STATE OF NORTH CAROLINA
DEPARTMENT OF TRANSPORTATION

Addendum No. 1

RE: Contract ID C203600

US-19/64 From West Of Bridge #10 To End of Divided Highway

PROJECT REFERENCE NO.		SHEET NO.
14CR.10201.6		2
STATE PROJECT	F.A. PROJECT NO.	DESCRIPTION
14CR.10201.6

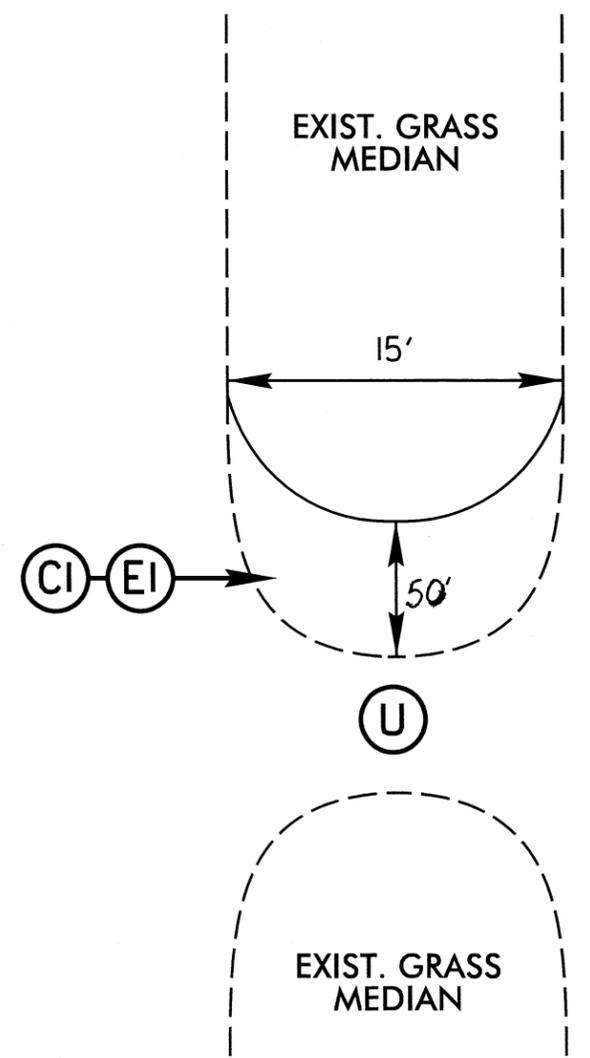
On Sheet No. 2 a dimension has been revised in the plan view of the crossover widening. Please void Sheet No. 2 in your plans and staple the revised Sheet No. 2 thereto.
